REFUSAL OF PLANNING PERMISSION

APPLICATION NO. 2019/1009

Proposal Erection of new detached dormer bungalow and detached garage
At Rose Cottage, 86 Mexborough Road, Bolton Upon Dearne, Rotherham, S63 8LX

DRAWING No :
MS/075/19
- 01

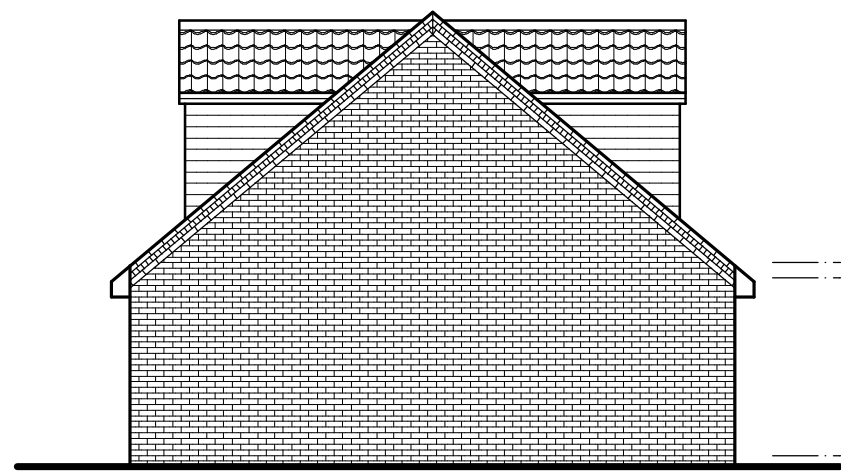
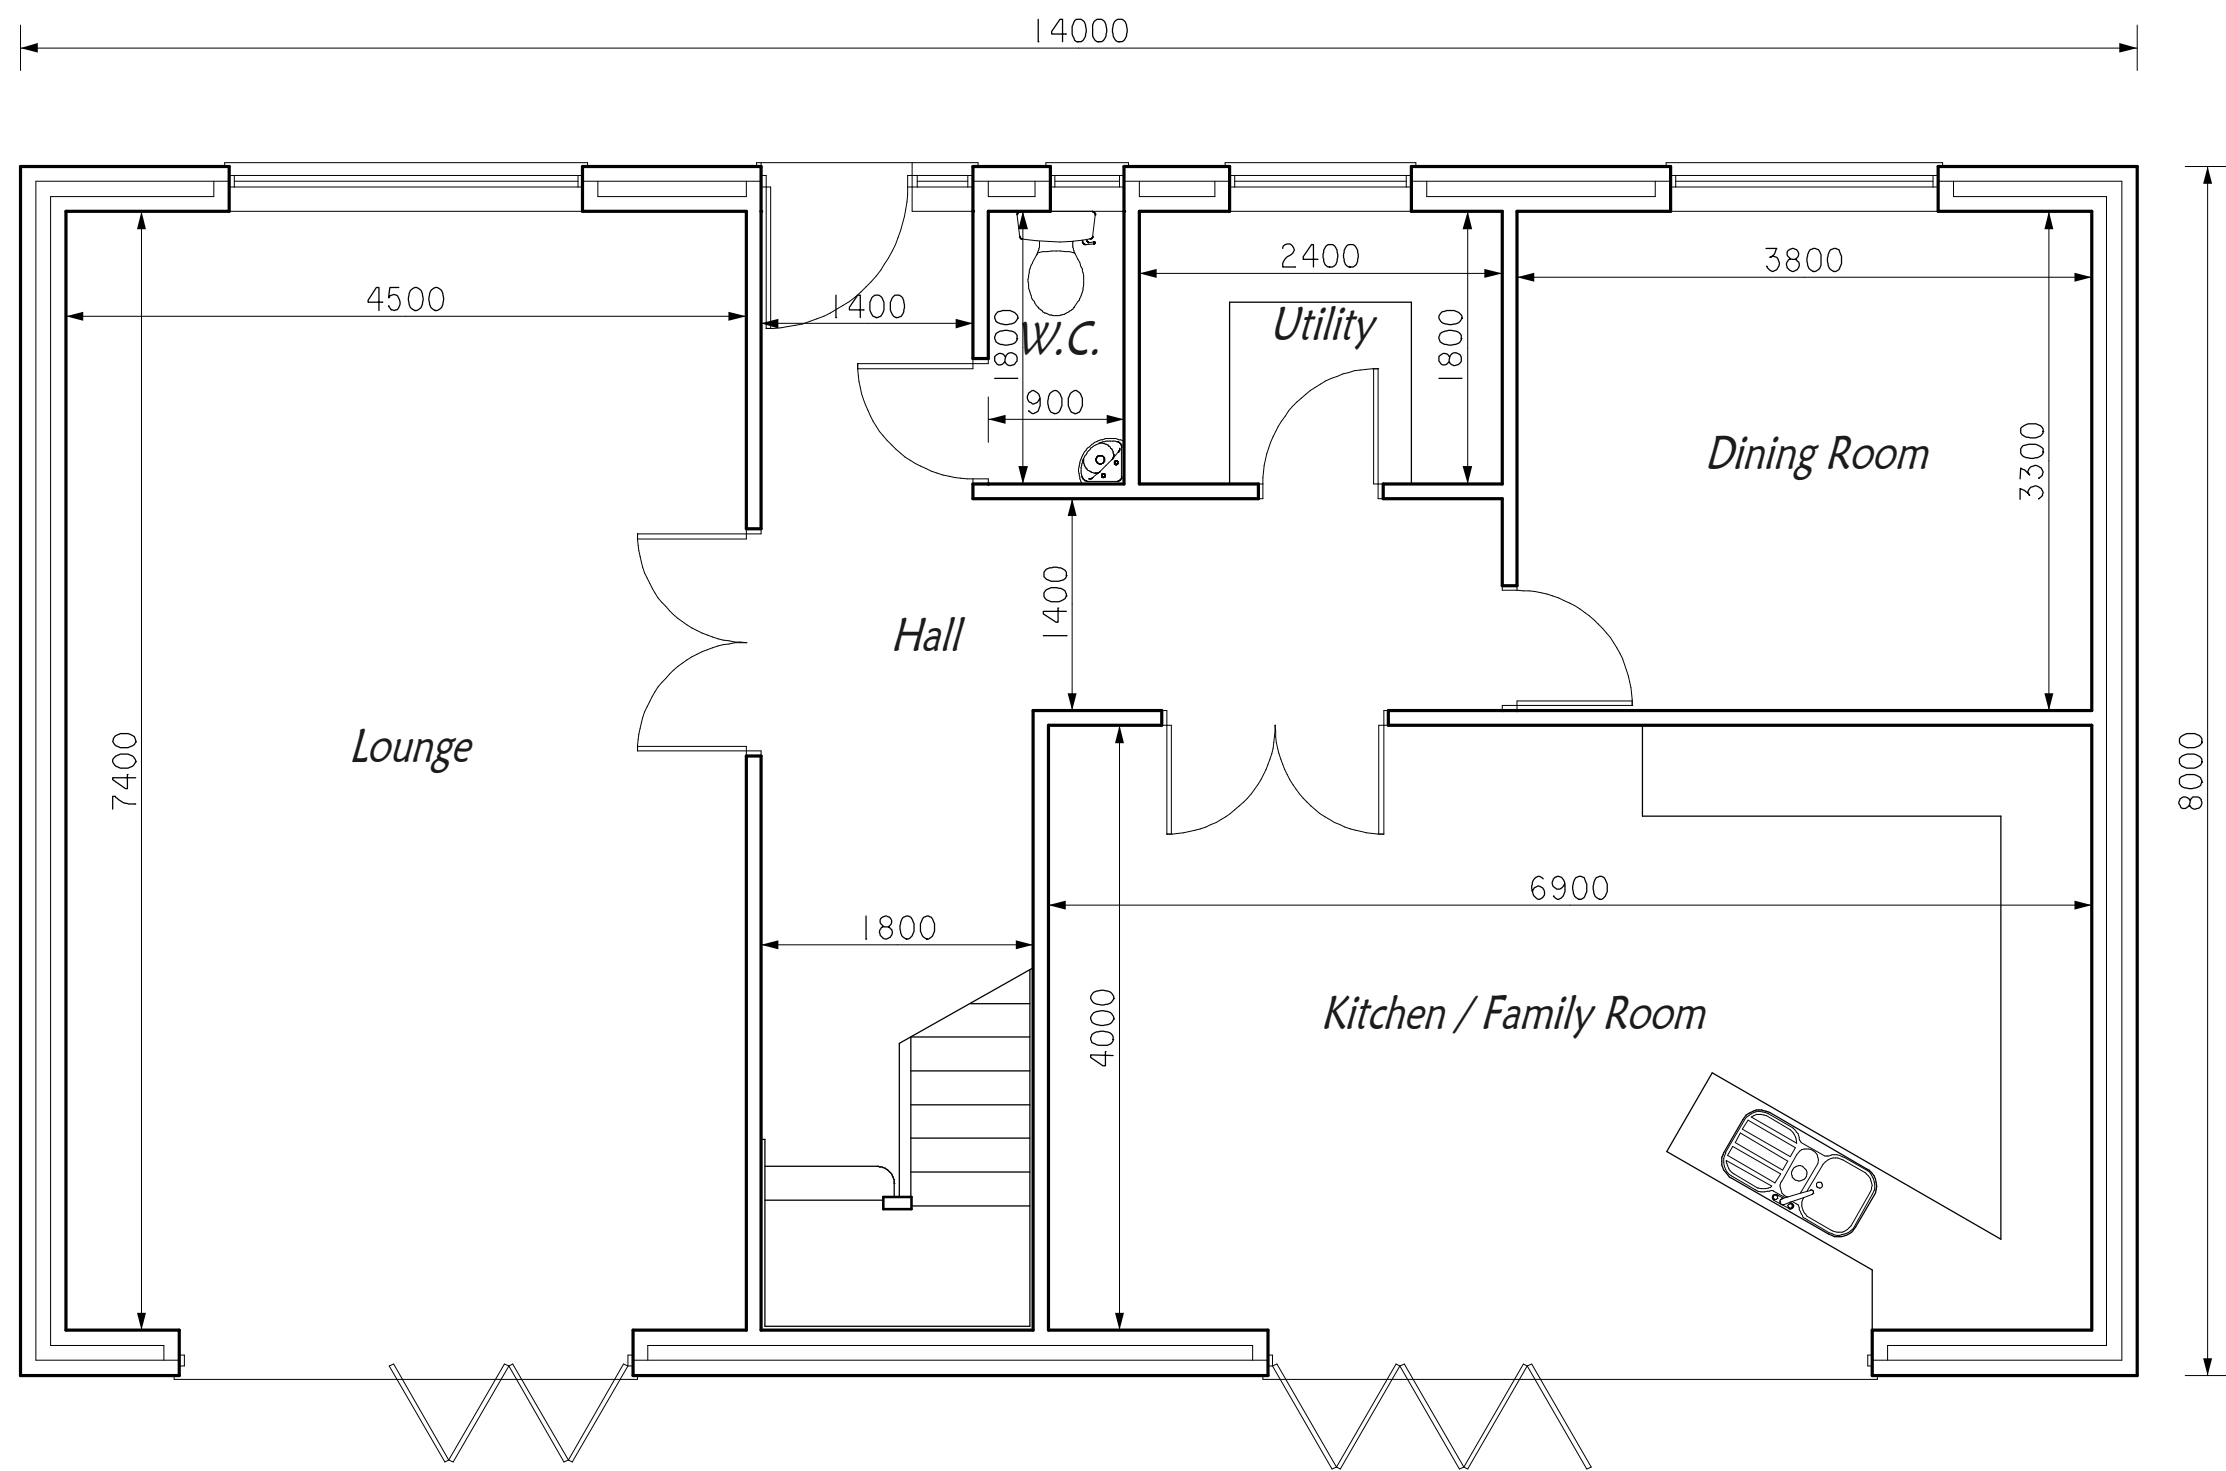
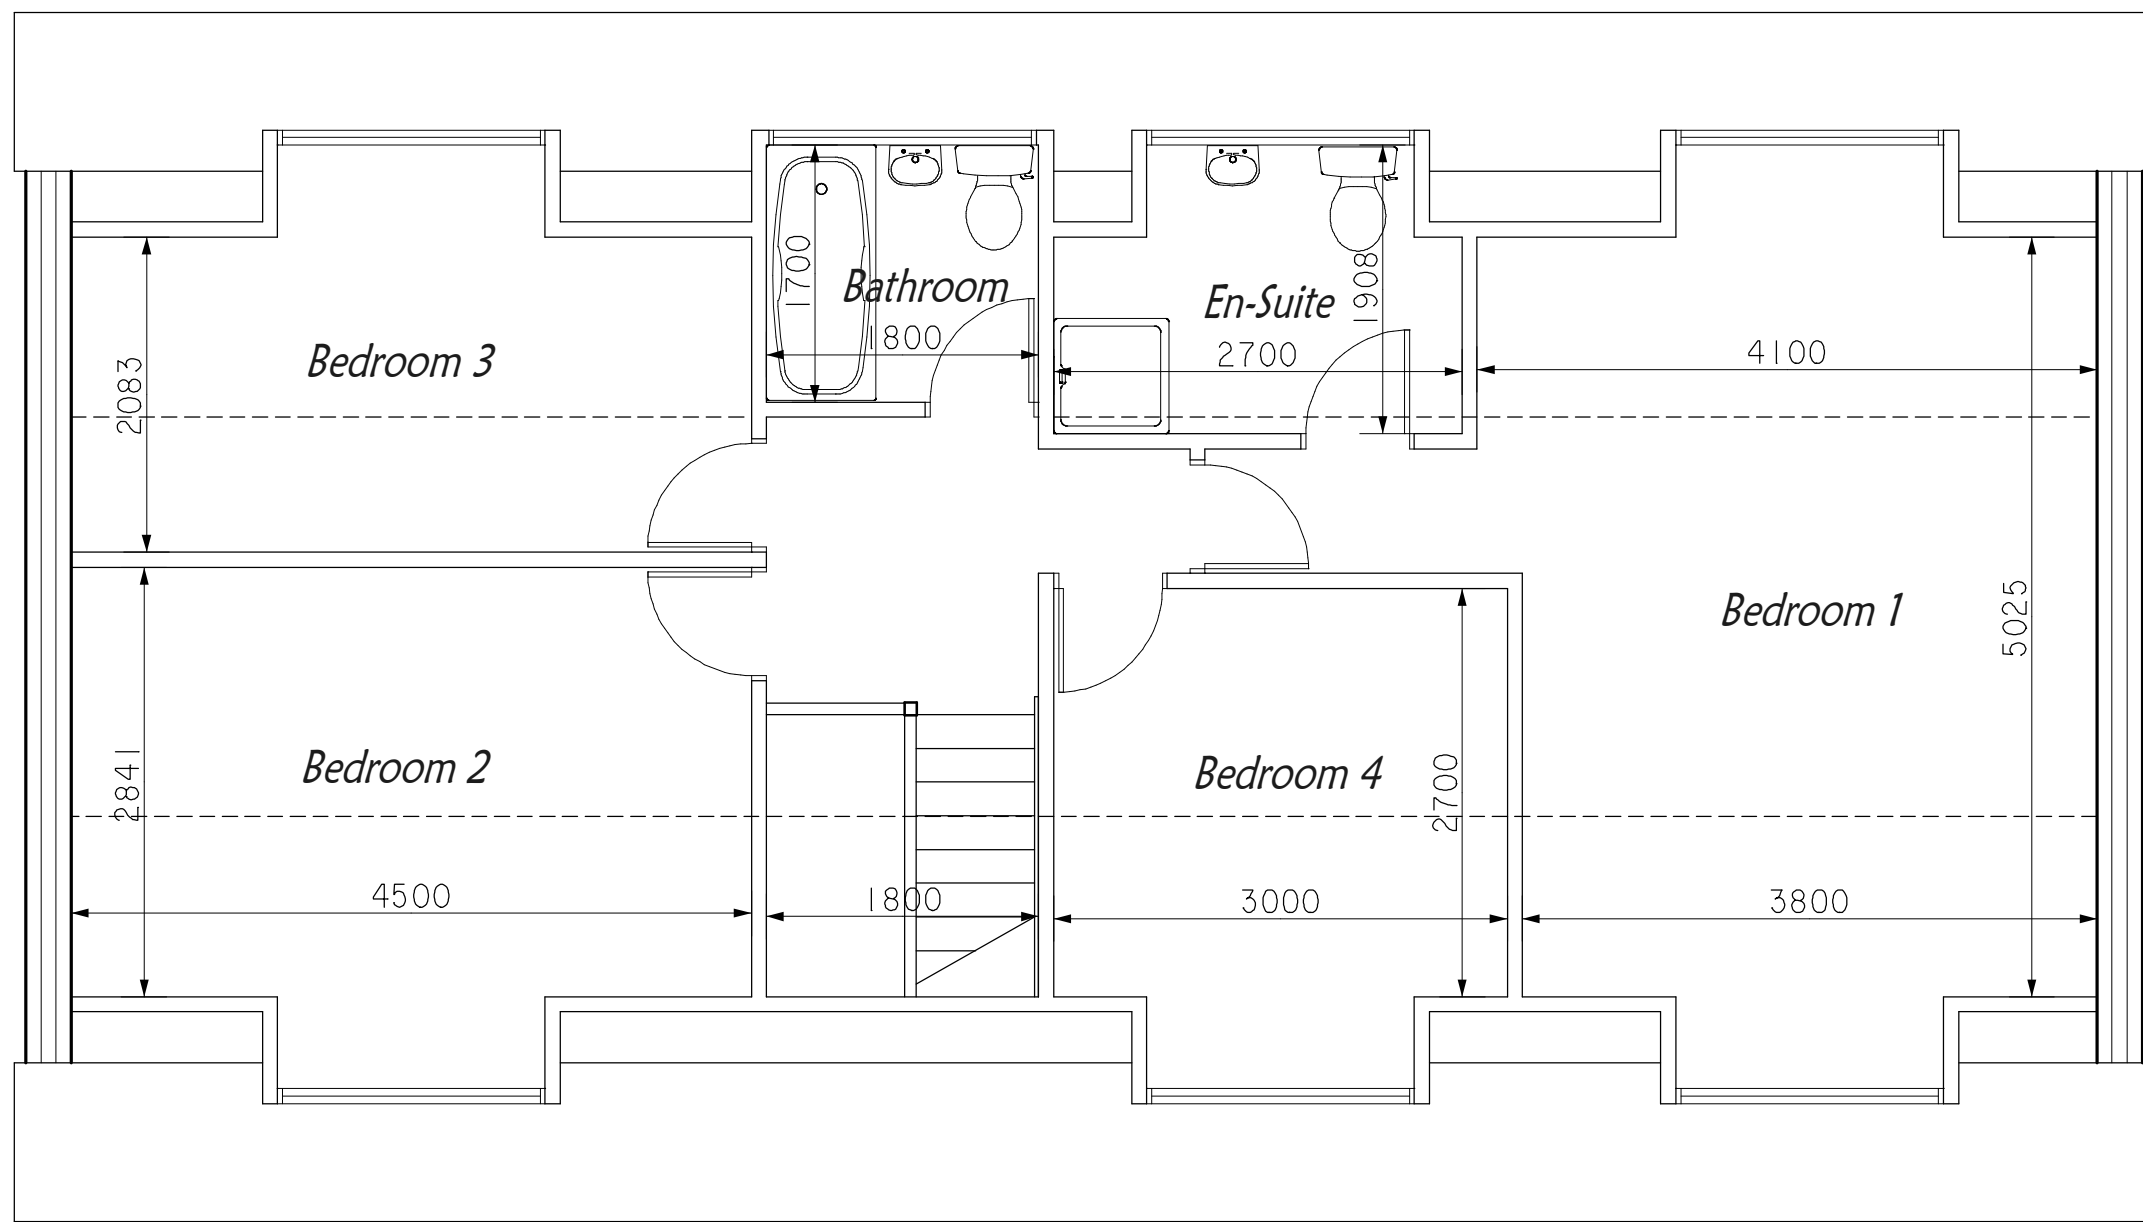
- 3 In the opinion of the Local Planning Authority, the inclusion of dormers on the frontage of the proposed dwelling is not considered to be in character with the surrounding area given that the local area has no visible examples of dormers on the front or side elevations of nearby properties. As such, the proposed development is considered contrary to Local Plan Policy D1: High Quality Design and Place Making and Supplementary Planning Document (SPD): Design of housing development as the introduction of dormers does not respect, complement or enhance the street scene in terms of design and visual amenity.
